# Memorandum

Date: November 1, 2018

Subject: Falcon Landing Drainage Letter

PPR-18-053

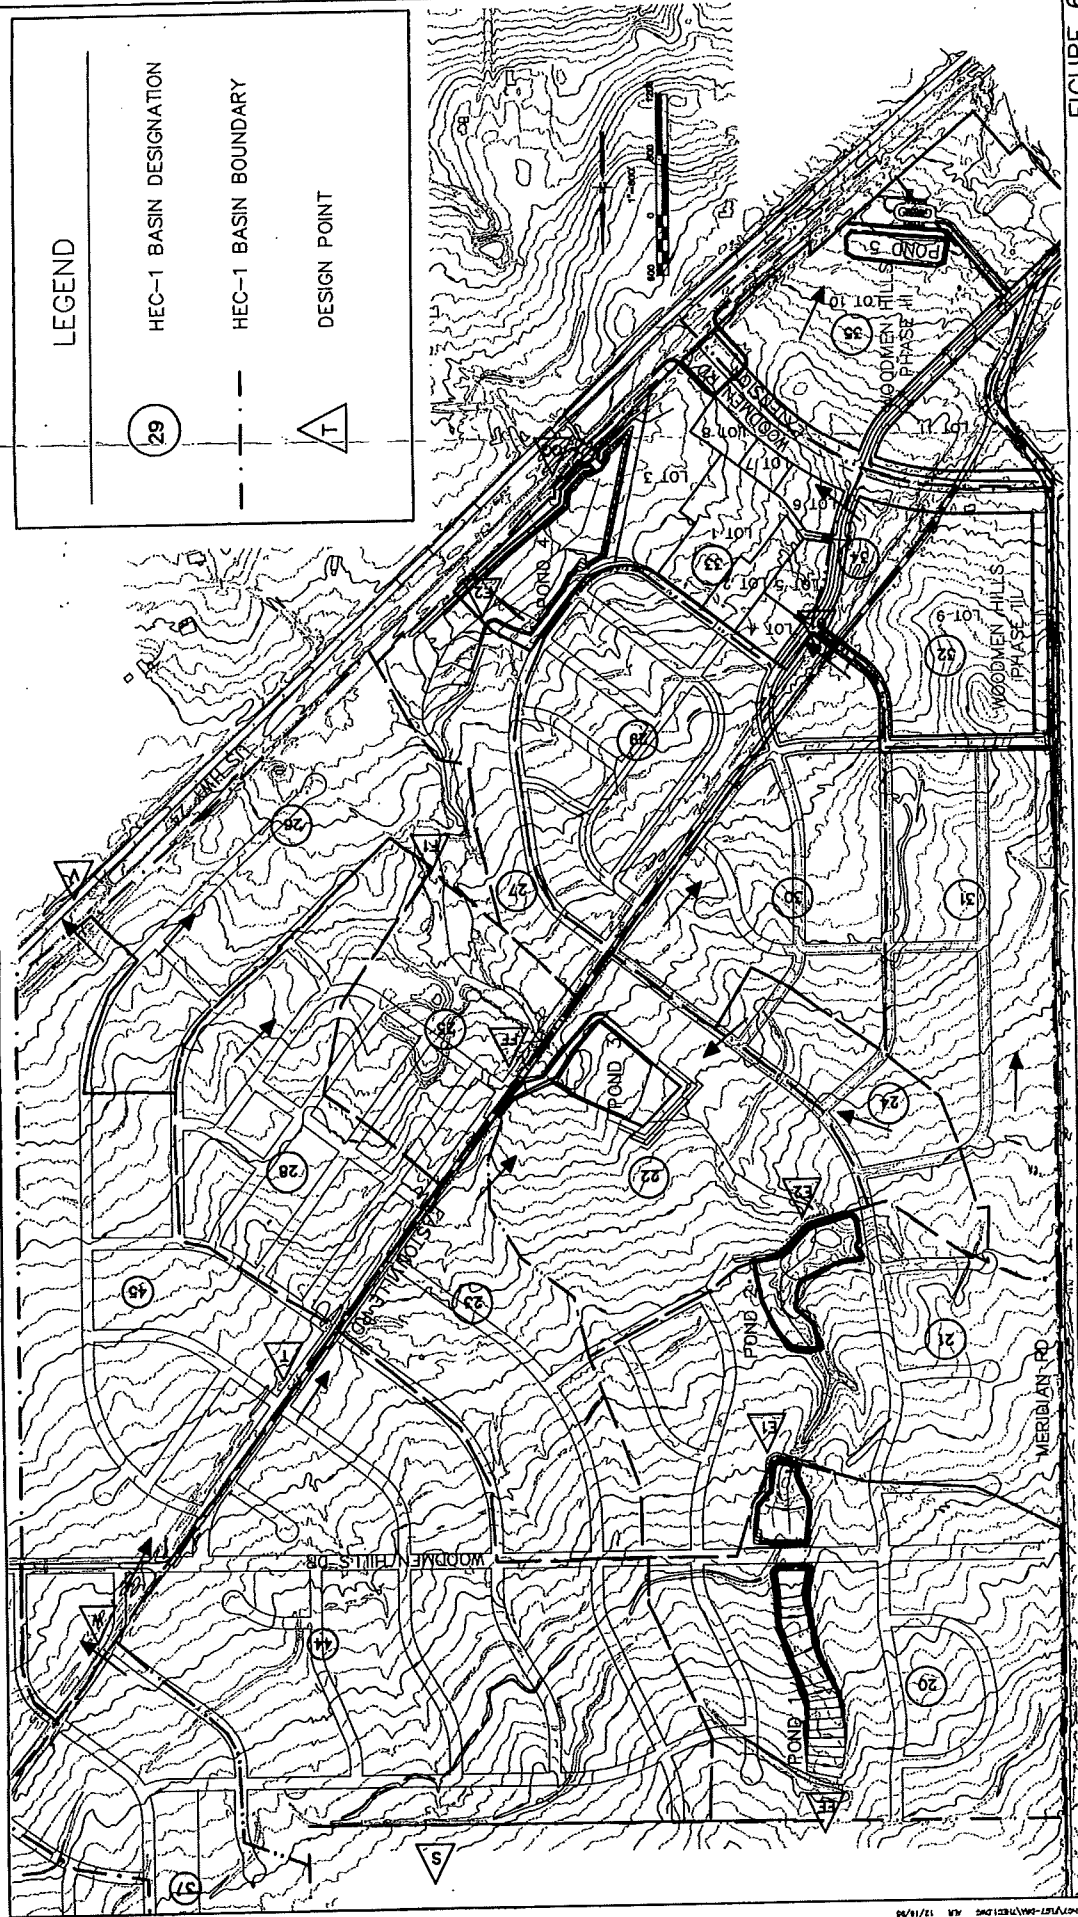
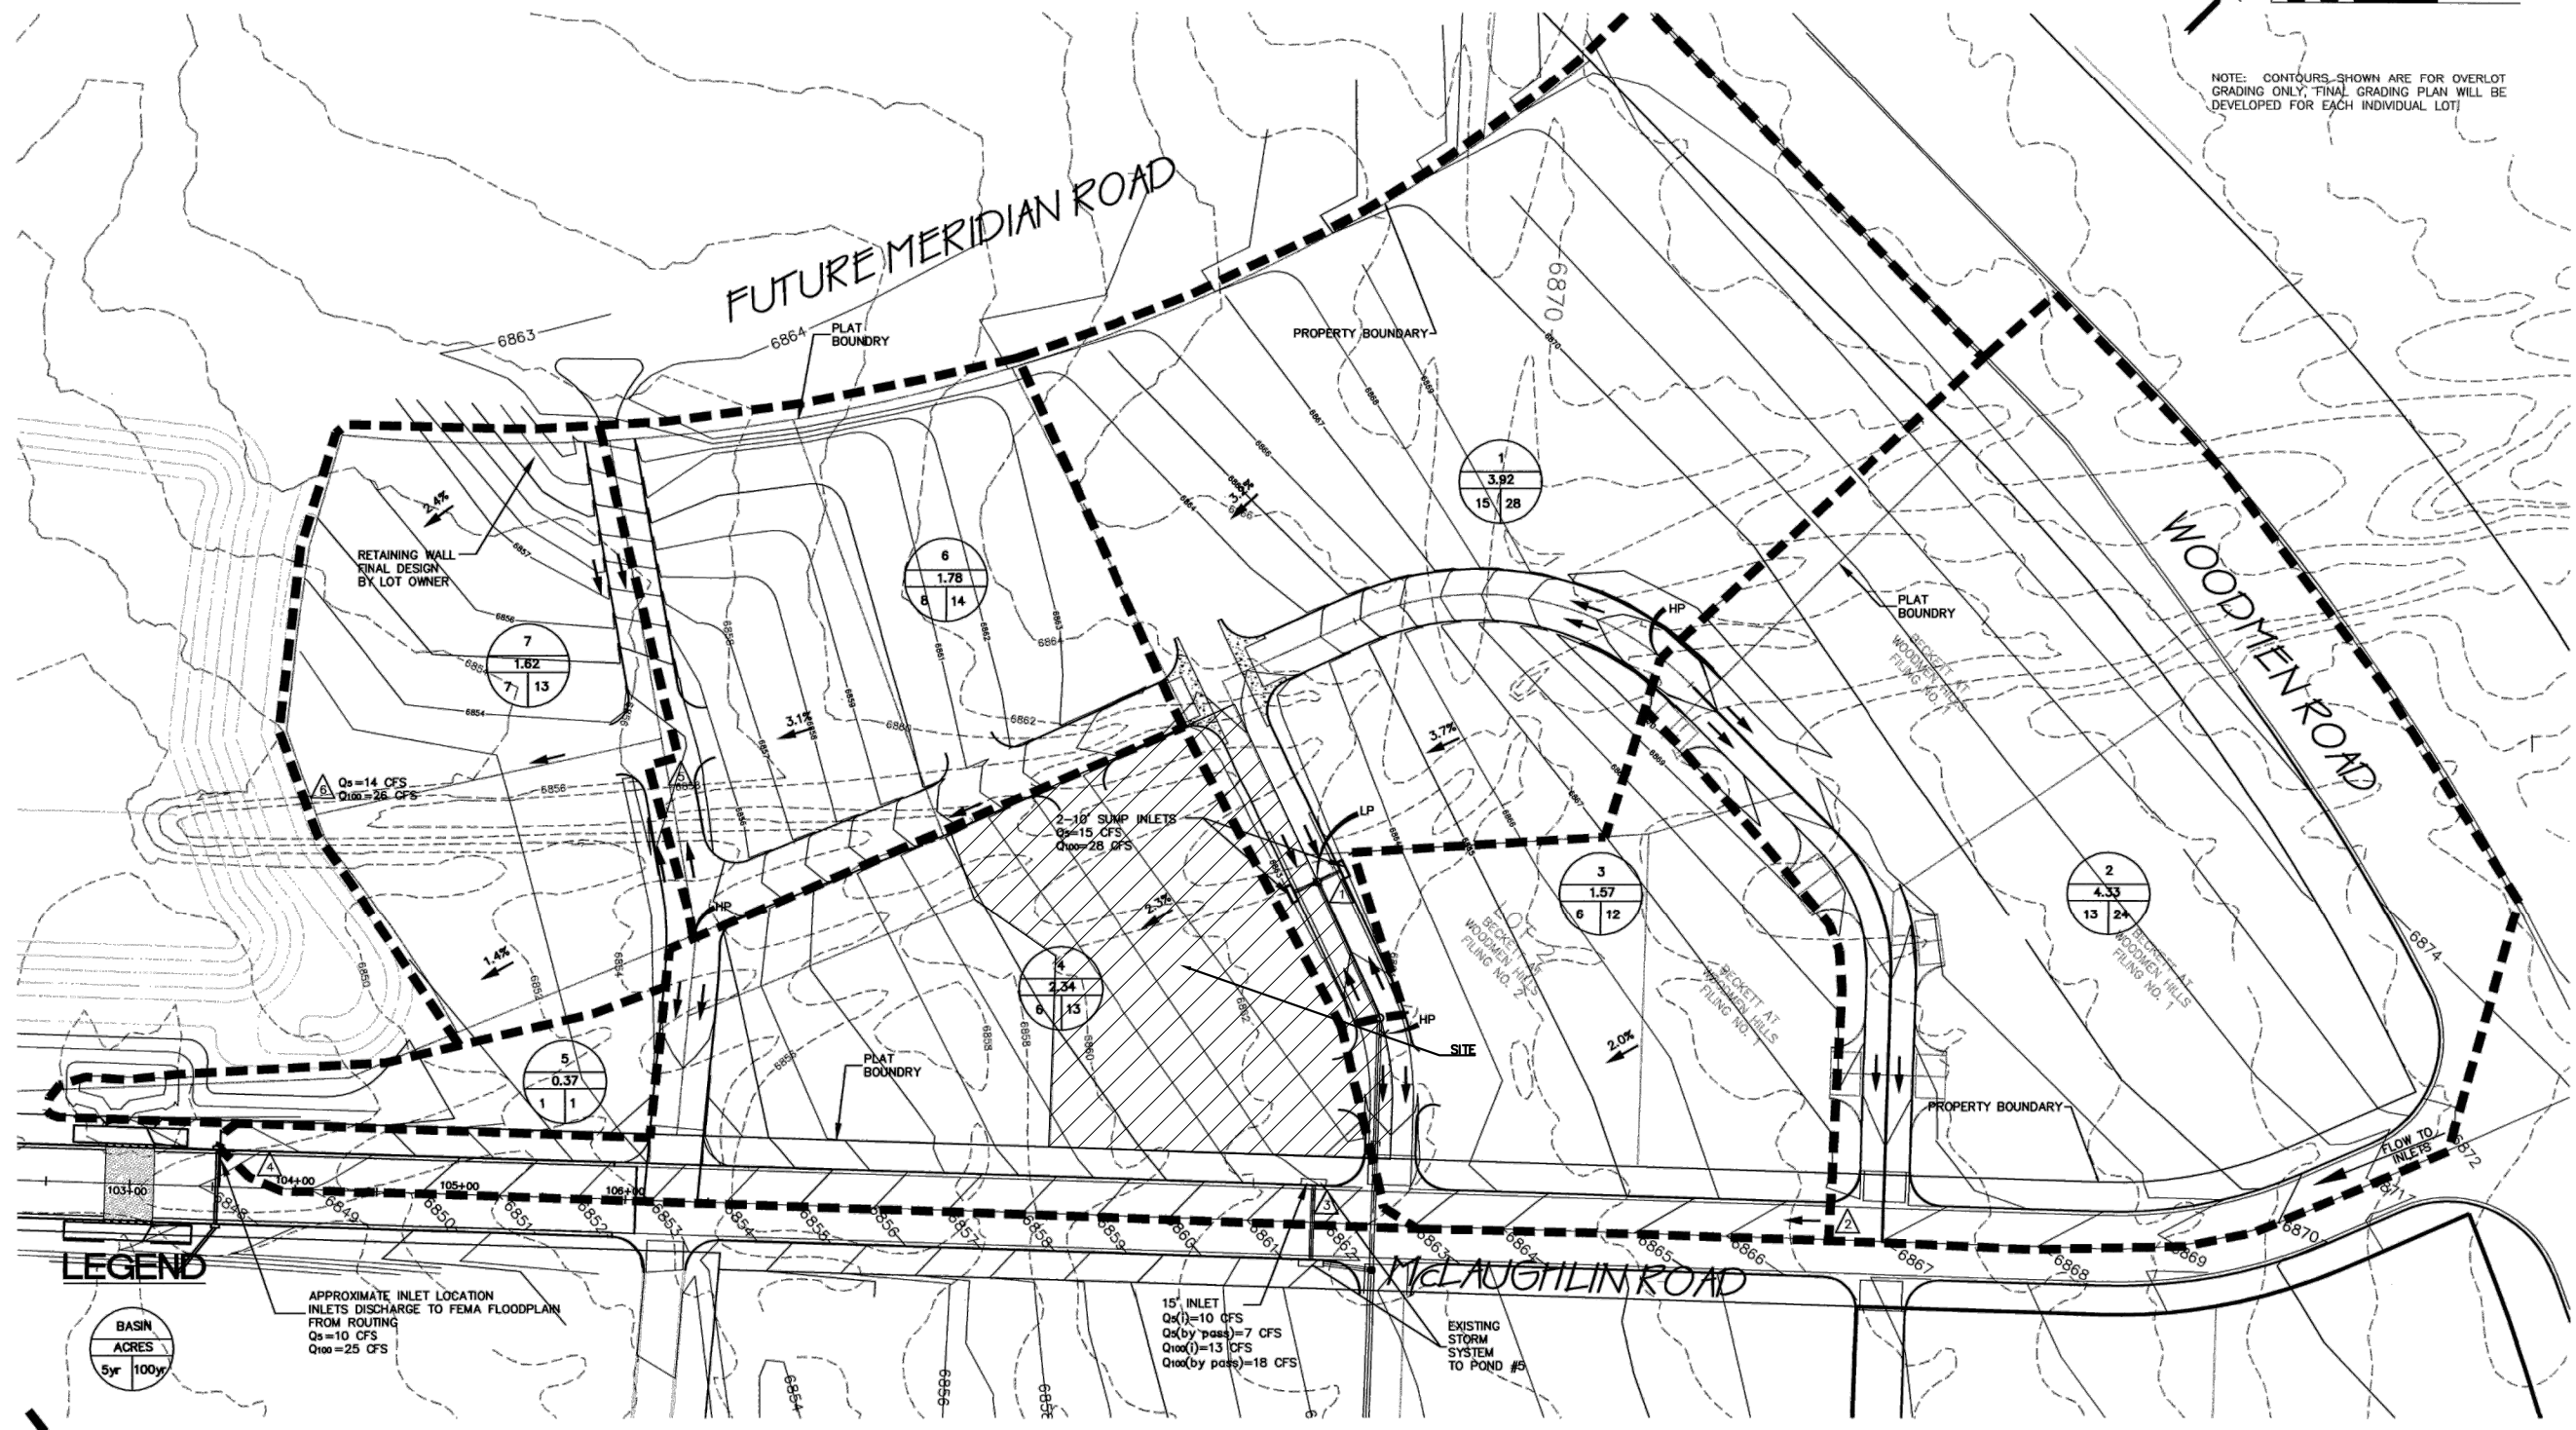
Steve K or Jeff-What is this? We need a drainage plan- don't we?. Where is the water going to. And is the pond they think the water is going to built for all the development or is it undersized?

Please provide a drainage letter that is in conformance with the criteria DCM Vol 1 section 4.5" Small drainage report format".  
Add a section to address the "4 step process".  
DCM Vol 2 section 4.1 & El Paso County ECM I.7.2.  
Provide a drainage map page in the report that shows the site drainage and the outfall.  
Provide the construction drawing for the PLD for this site. (we noted this exists in PPR-08-022, construction drawings)  
Provide a discussion in the report that this PLD is constructed per the requirements and was inspected, and has the capacity for WQCV for this site.  
Provide updated UDFCD drainage calculations for the PLD.
